RE: LP-24-24-00002, Nelson View
I-90 Exit 74, West Nelson Siding Road, Vicinity

In future correspondence please refer to:
Project Tracking Code: 2024-04-02693
Property: Kittitas County_Nelson View 5-Lot Subdivision (LP-24-00002)
Re: Survey Requested

TO: All Staff
FROM: Public Works Plan Review Team
DATE: April 24, 2024
SUBJECT: LP-24-00002 Nelson View

RE: LP-24-00002

**NELSON VIEW PLAT**  
A PORTION OF THE SOUTHEAST 1/4 OF SECTION 20,  
TOWNSHIP 20 NORTH, RANGE 14 EAST, W.M.,  
KITITITAS COUNTY, WASHINGTON

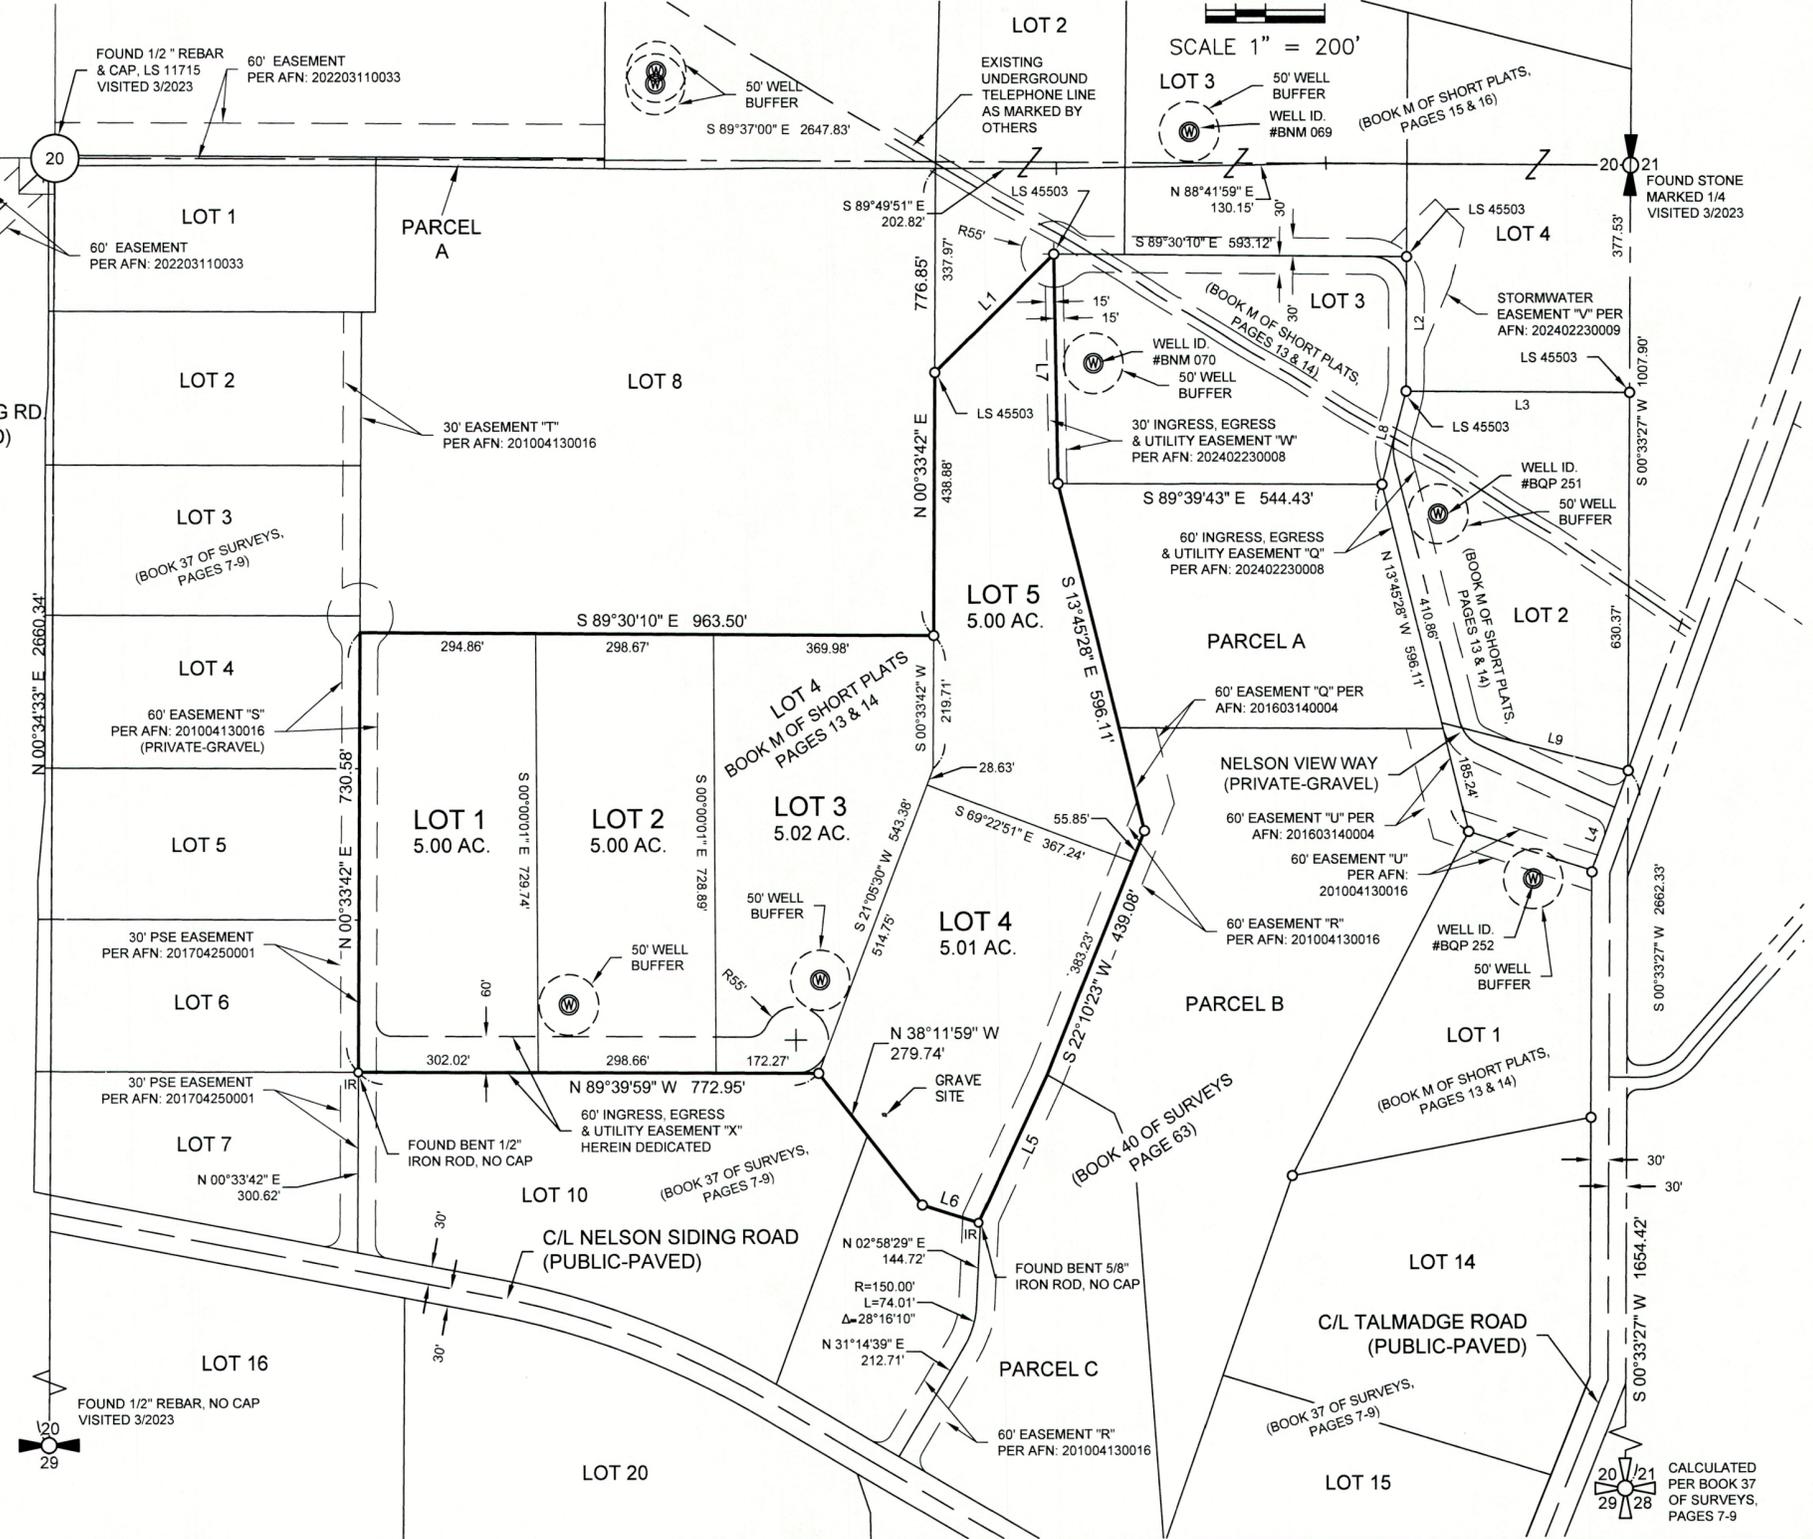
The proposal shows future development of a road near the southern border of the parcel. This road, potentially, runs through an area that has been identified as a potential wetland area by the National Wetland Inventory and Kittitas County Planning GIS data. Additionally, along the eastern portion of the property, LiDAR imagery shows that a stream channel of some form is present. The channel appears to be a distributary of Big Creek.

Prior to ground disturbance, a wetland determination, delineation, and rating should be completed if this has not previously occurred.
